CITY OF ALBUQUERQUE

October 8, 2021

**Re: Keenan Properties
12900 Central Ave SE
30-Day Temporary Certificate of Occupancy
Transportation Development Final Inspection
Engineer's/Architect's Stamp dated 6-27-18 (L22D061)
Certification dated 09-29-21**

TRAFFIC CIRCULATION PLAN

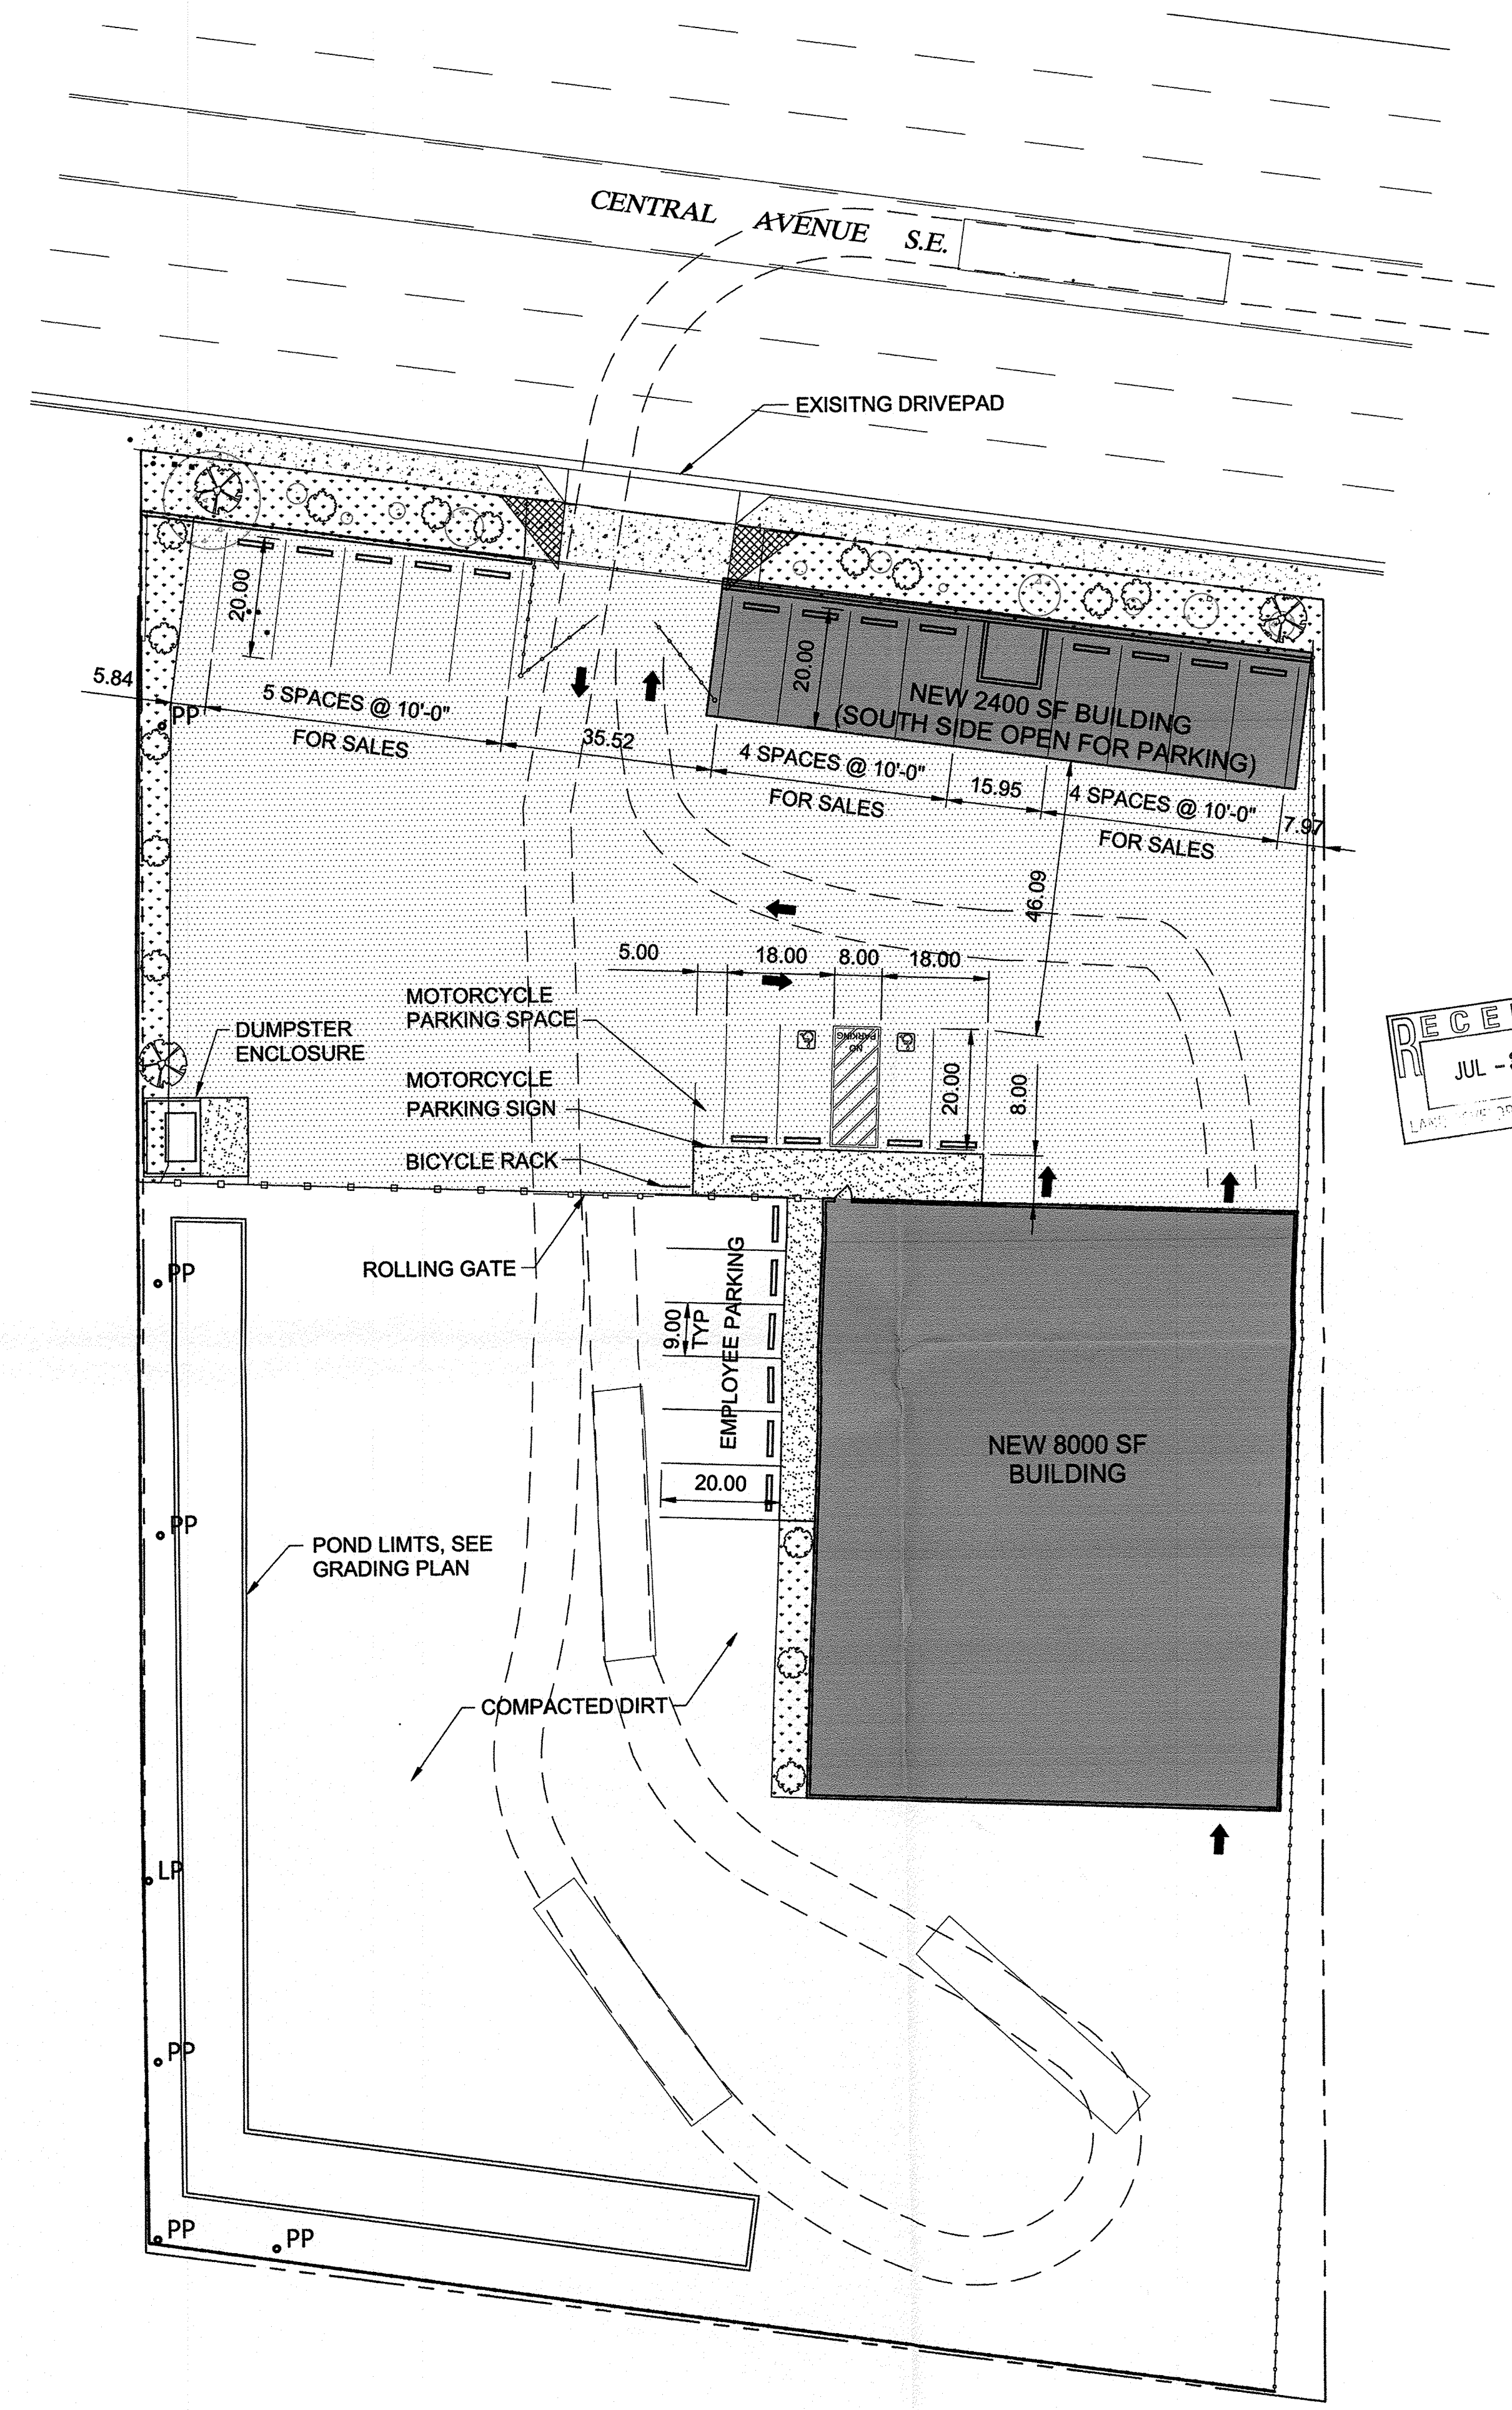
- Please add Motorcycle Sign, MC Floor marking & Bicycle rack (Pics of corrections received 10-7-21)
- Please redline plan to reflect site changes.
